Planning Assessment Report

Application to Modify the Minister's Approval for the Sydney Water Facility, Potts Hill Reservoirs Site

Major Project 08_0049 MOD 1

Title
SITETWORKS PLAN
SHEET 1 OF 4

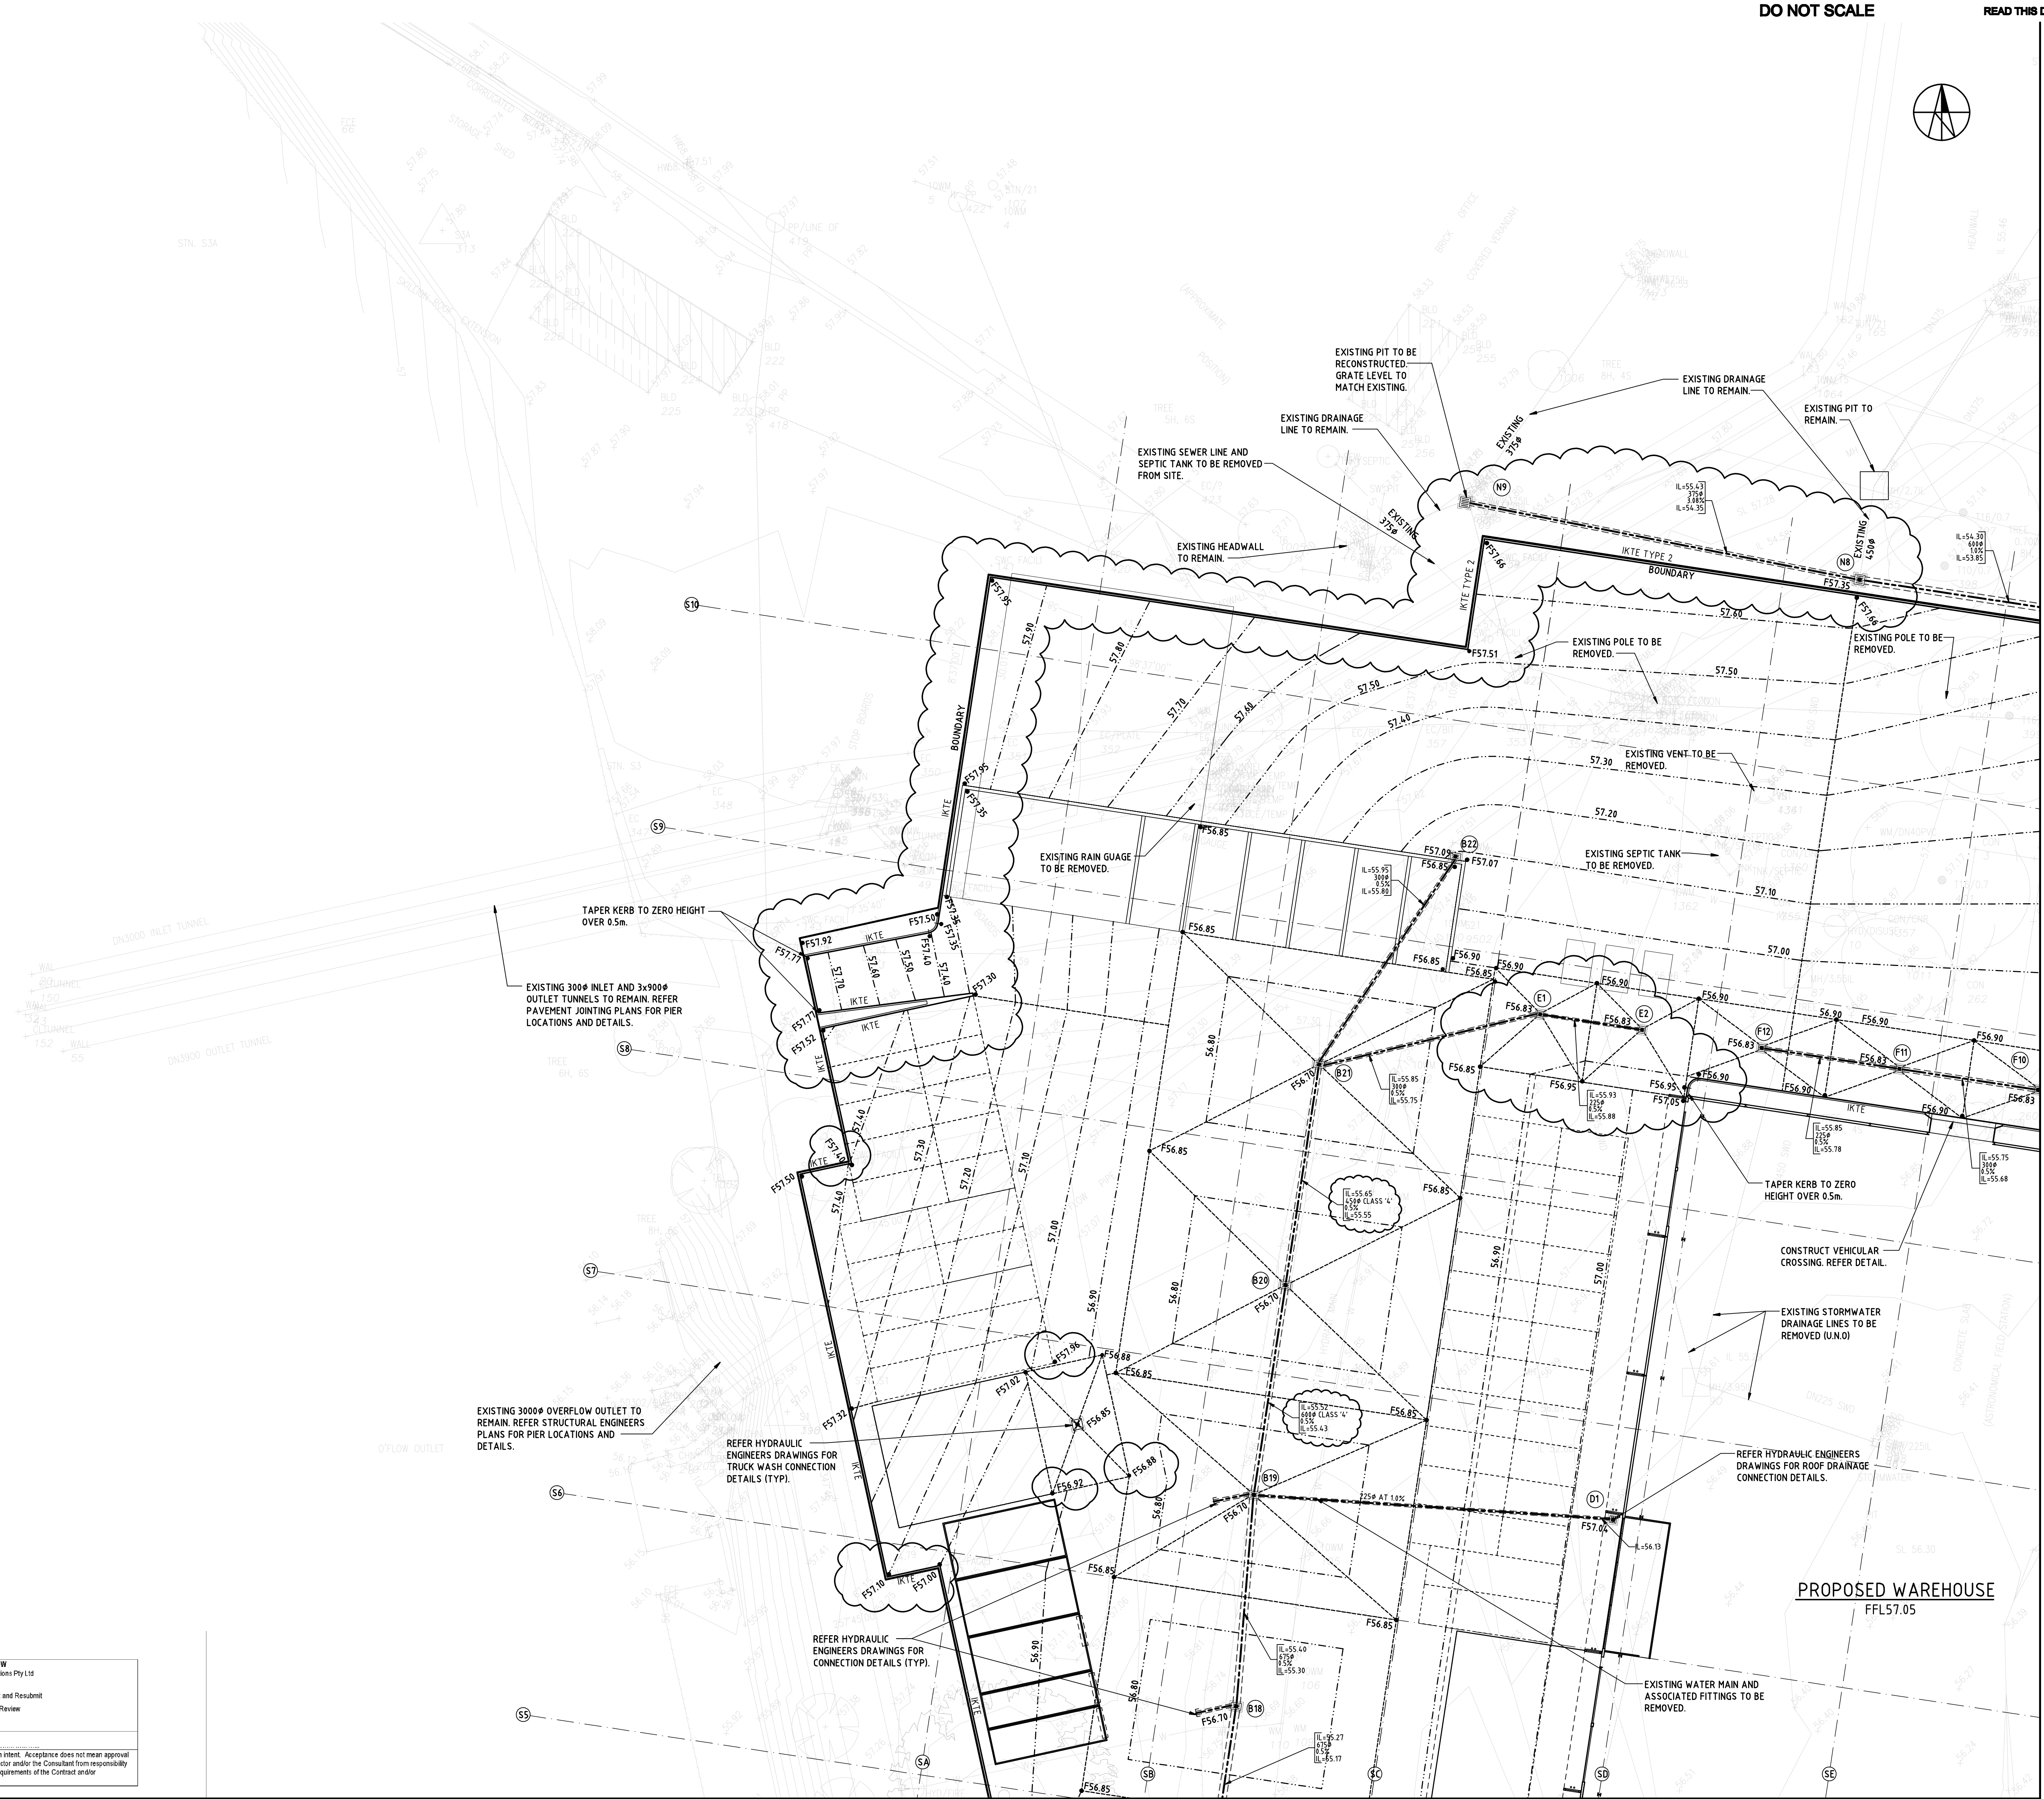
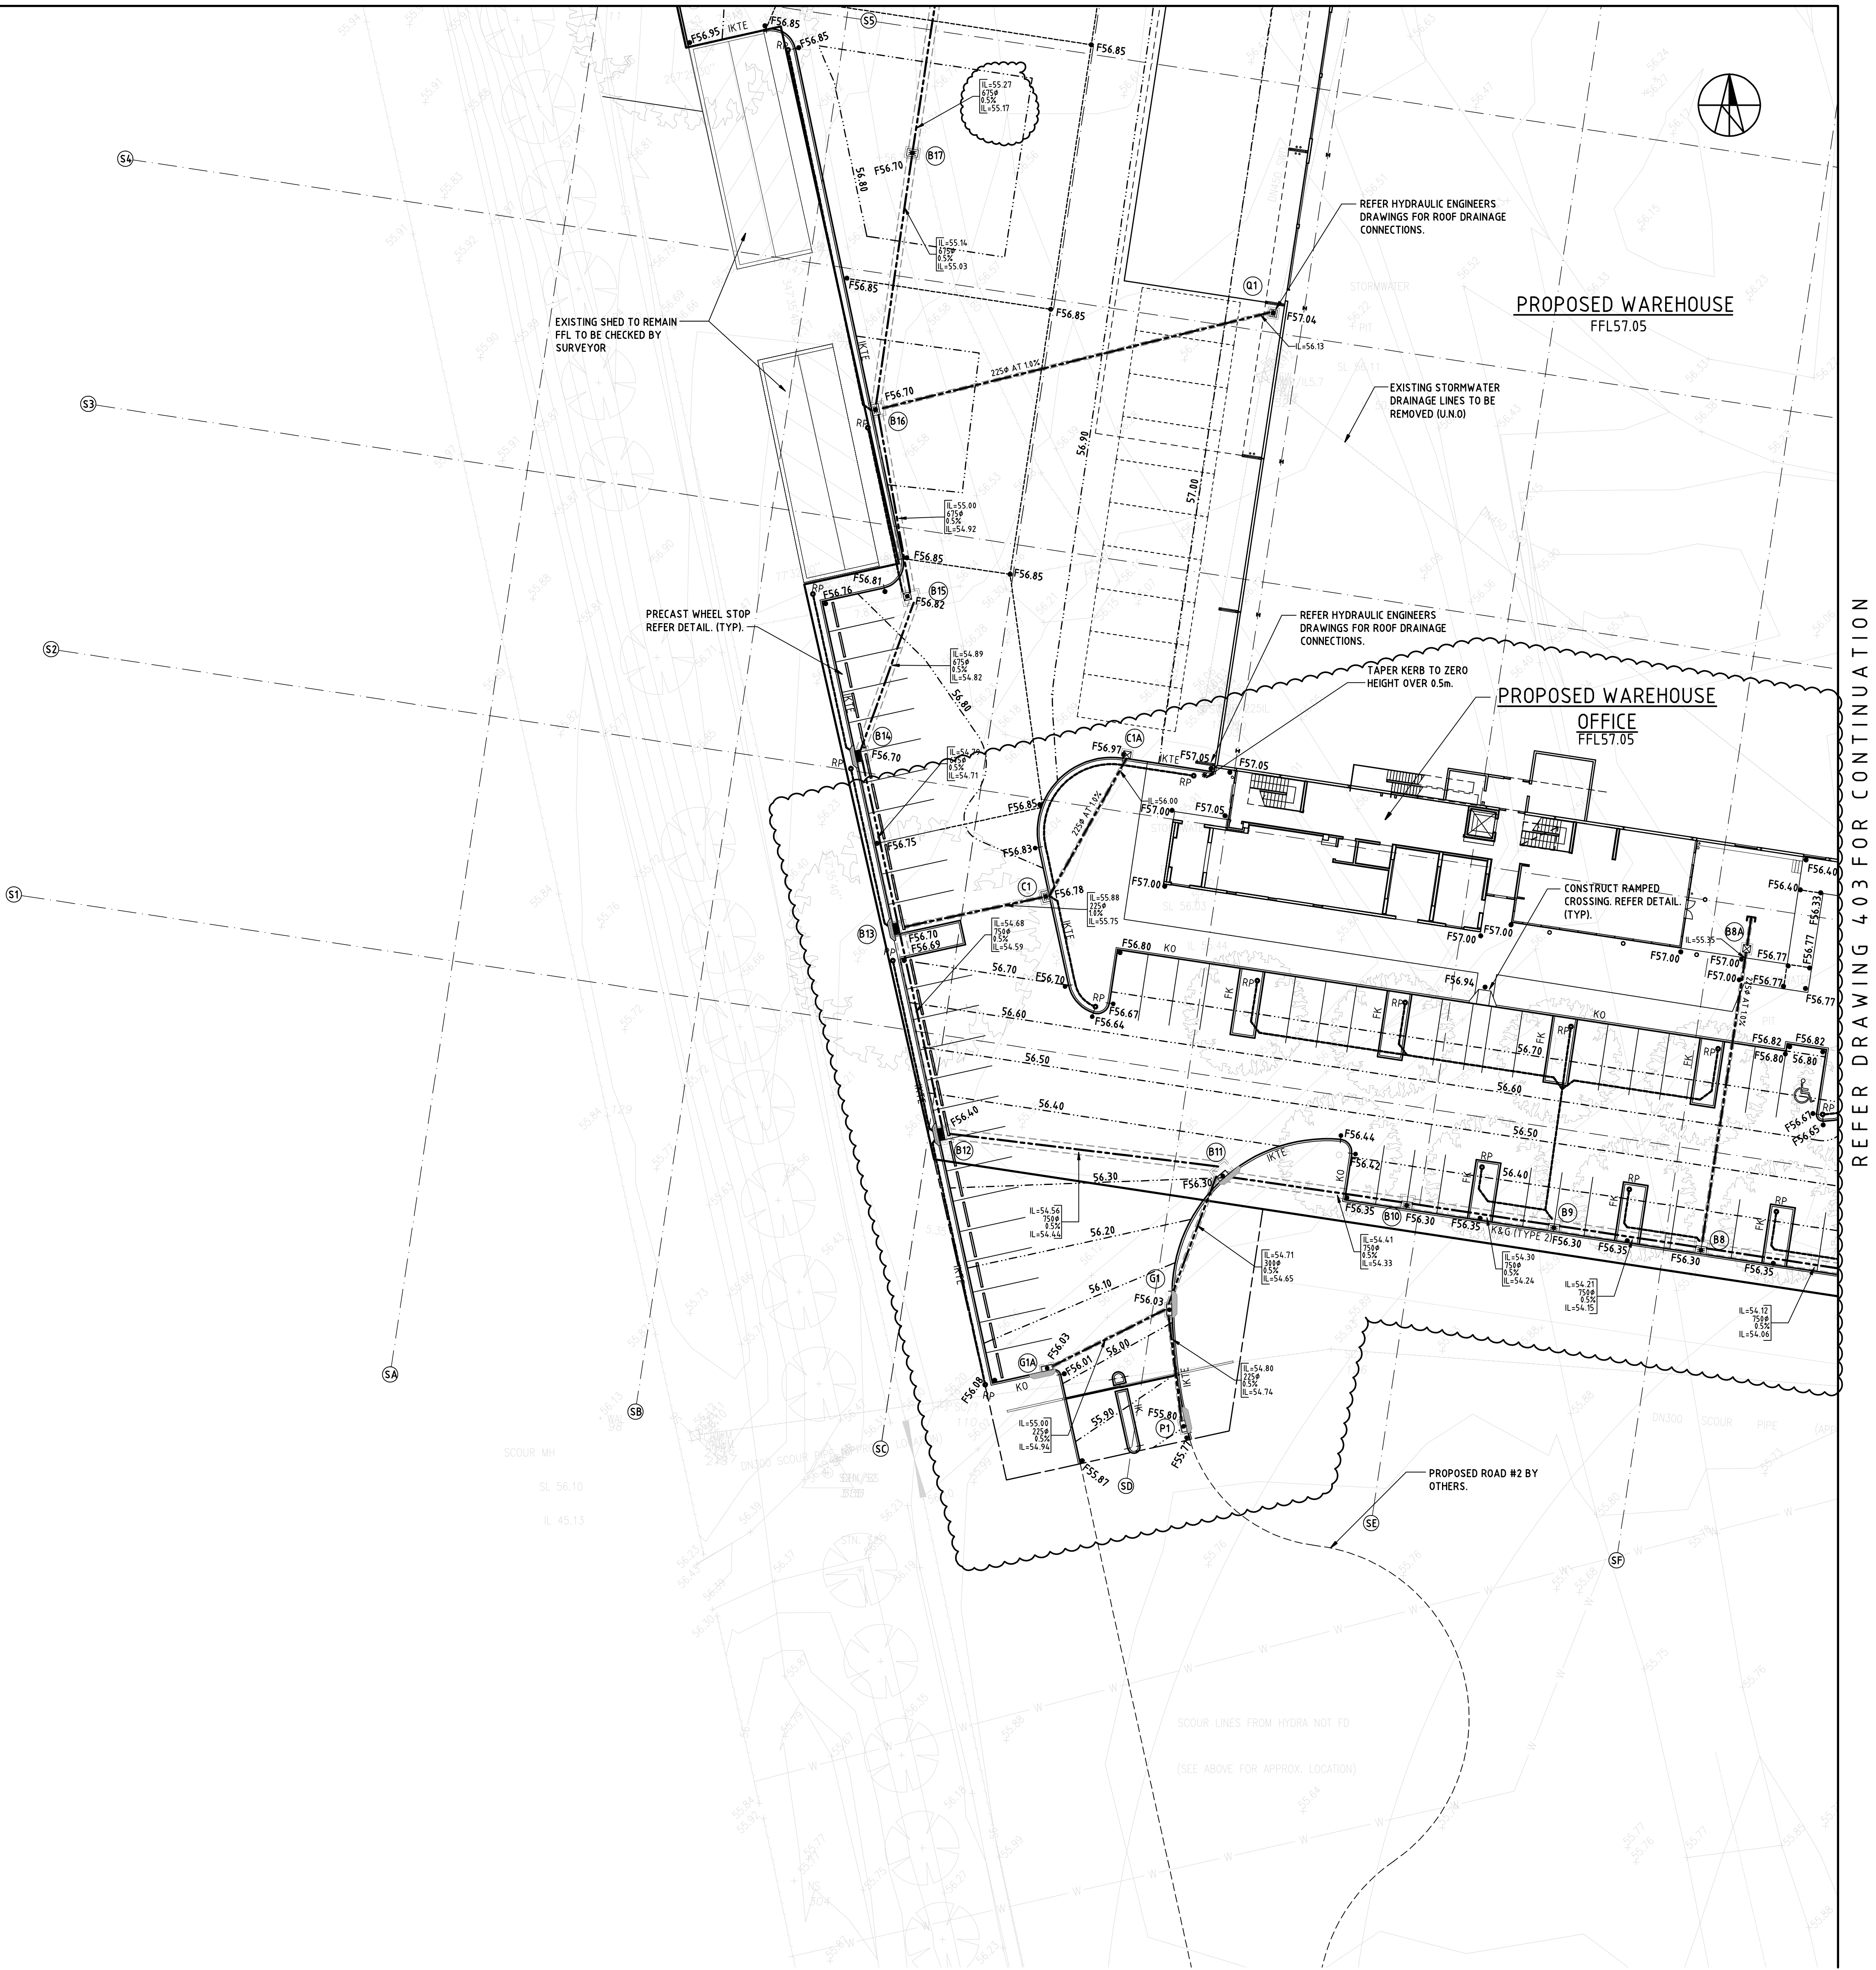
New civil works plans and an erosion and sediment control plan have been submitted to reflect the proposed modifications. A comprehensive construction management plan as detailed in Condition 6 of the approval will ensure excavation and construction activities will not impact surrounding residents, roads, properties, vegetation or heritage items.

- More detailed civil works, stormwater and sediment control plans consistent with layout changes and reflecting more detailed construction design.

Level B1 Floor Plan

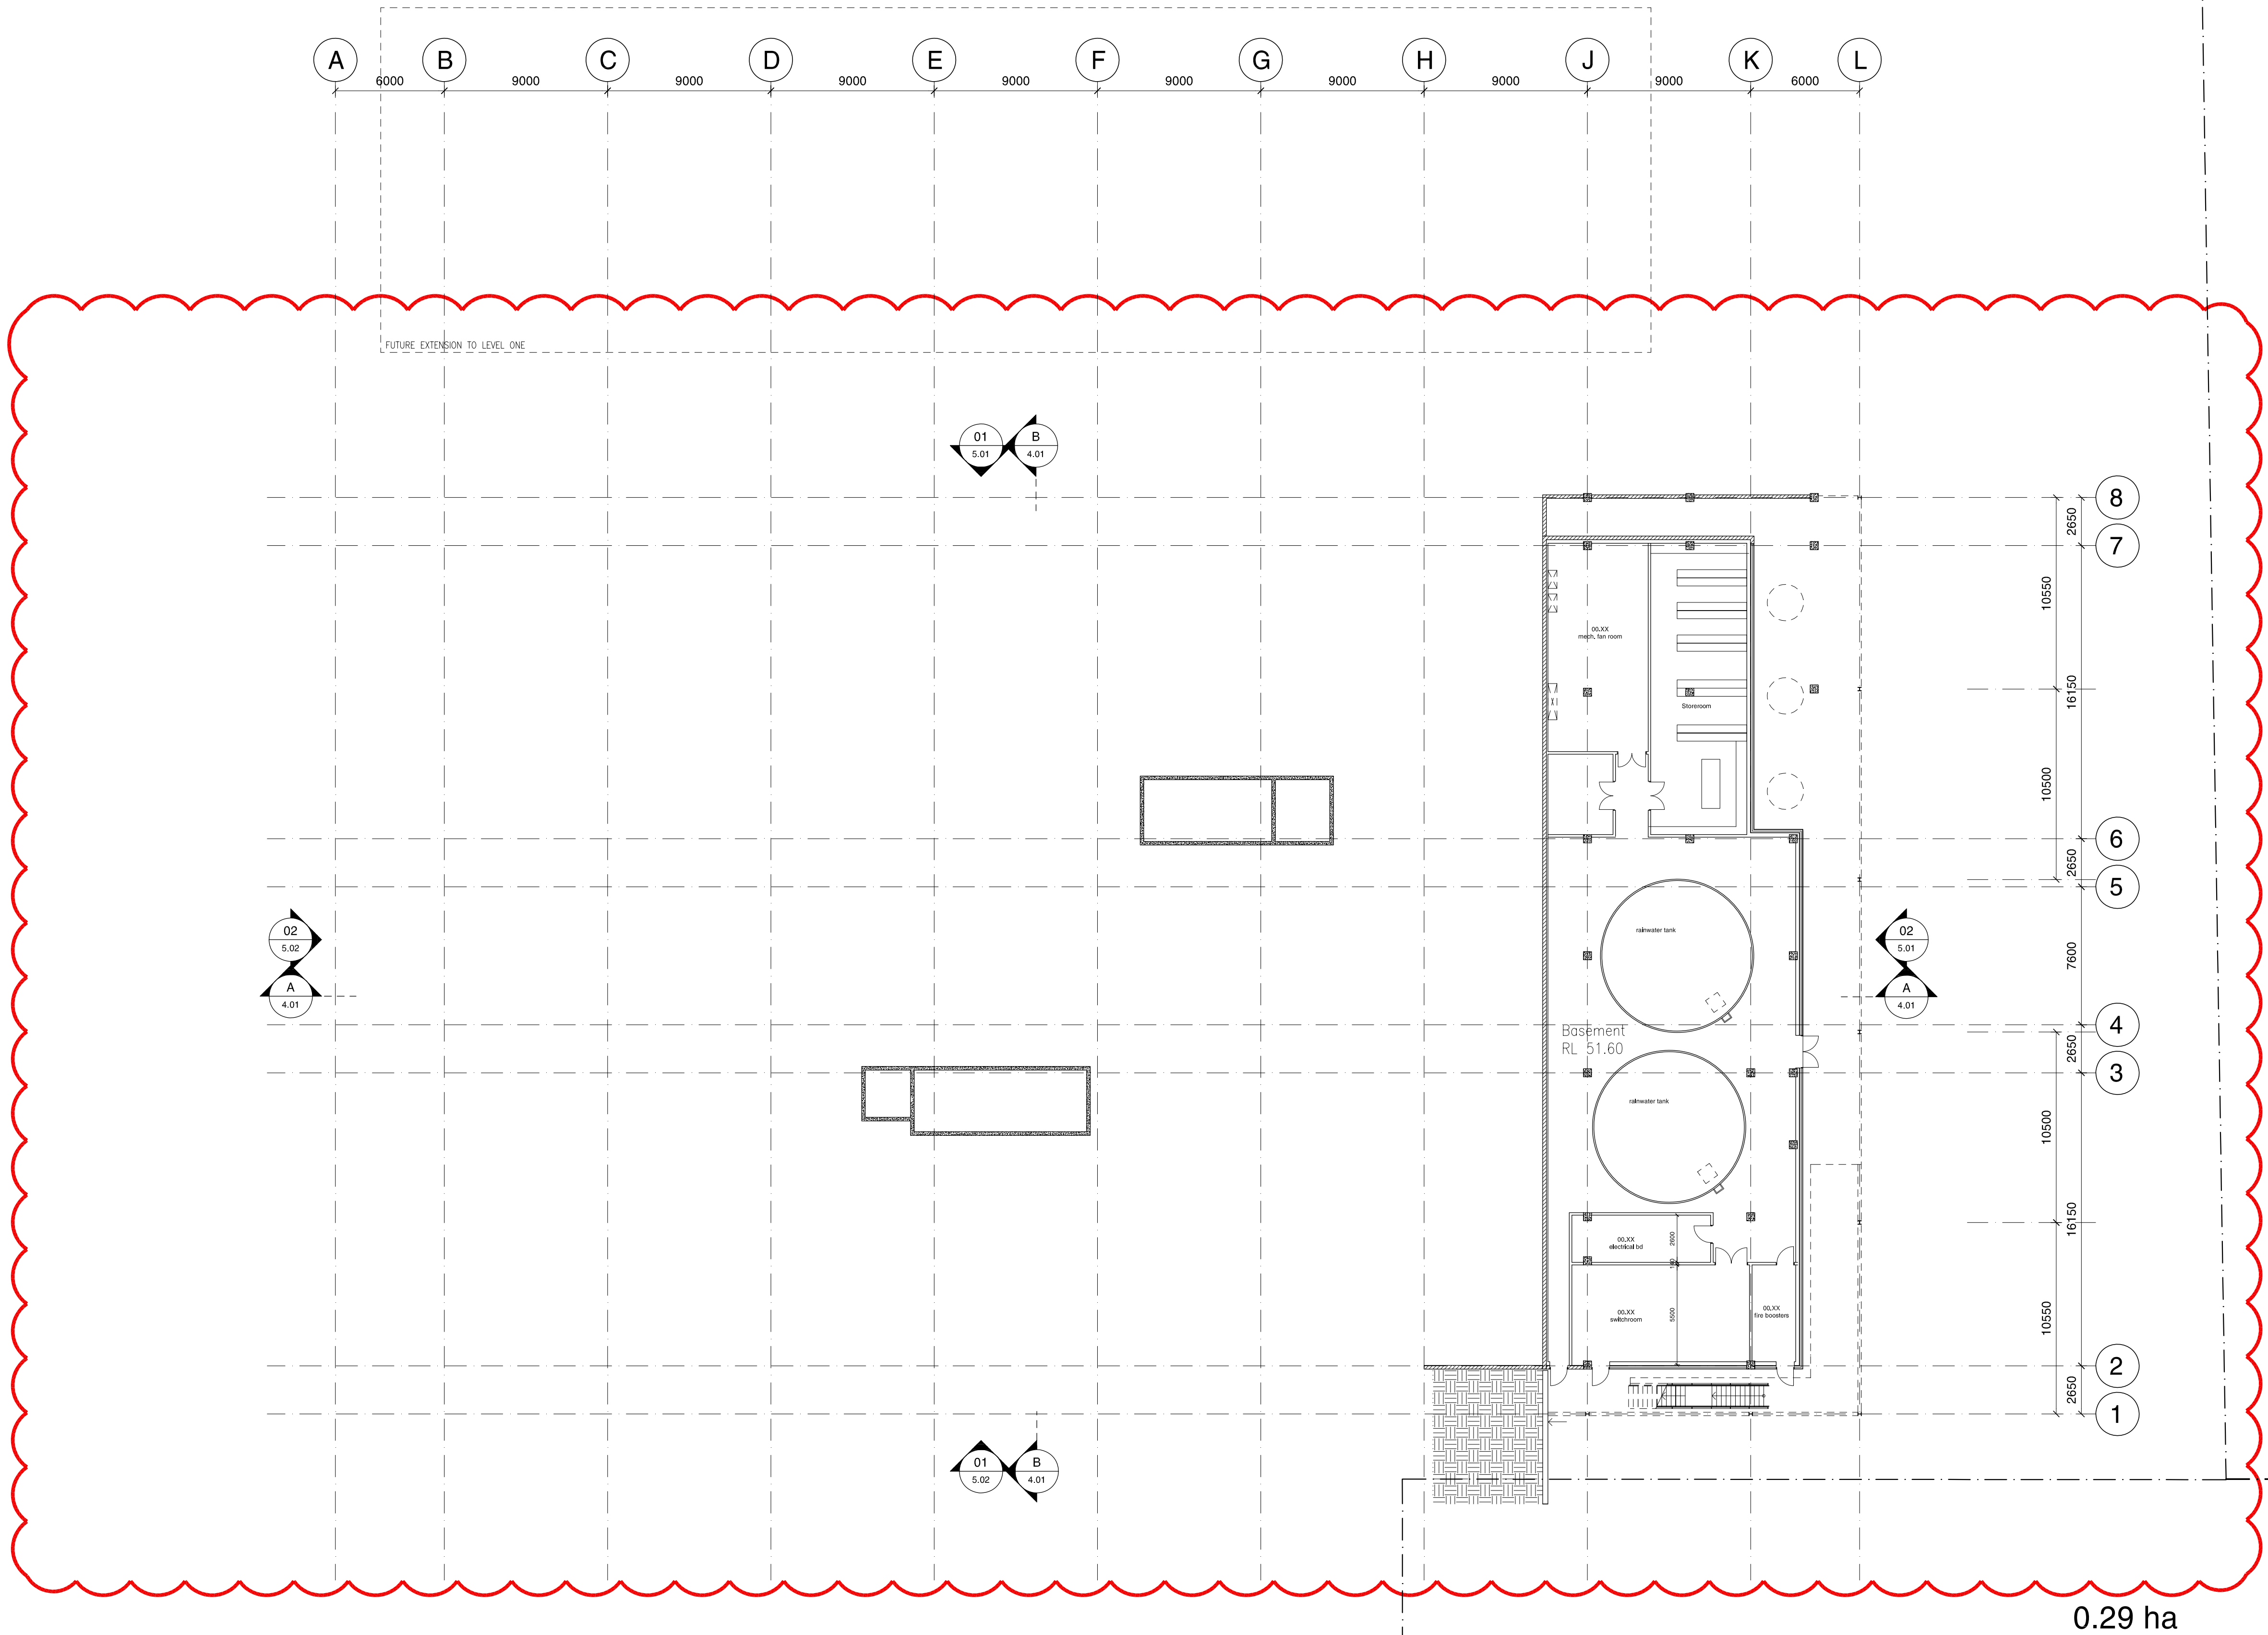
The approved development incorporated a rainwater tank below the timber deck where the natural ground level falls beneath the building. The modification seeks to enclose this area using a painted rendered blockwork. While this material is not consistent with the predominantly metal and glass used for the rest of the building, it is considered an appropriate material considering its partly below ground, set back position under the timber decking, allowing it to better blend with the ground with which it merges. Landscaping of the embankment will also screen this basement level.

- Basement level added to the office building principally for store rooms, plant rooms and rainwater tanks.
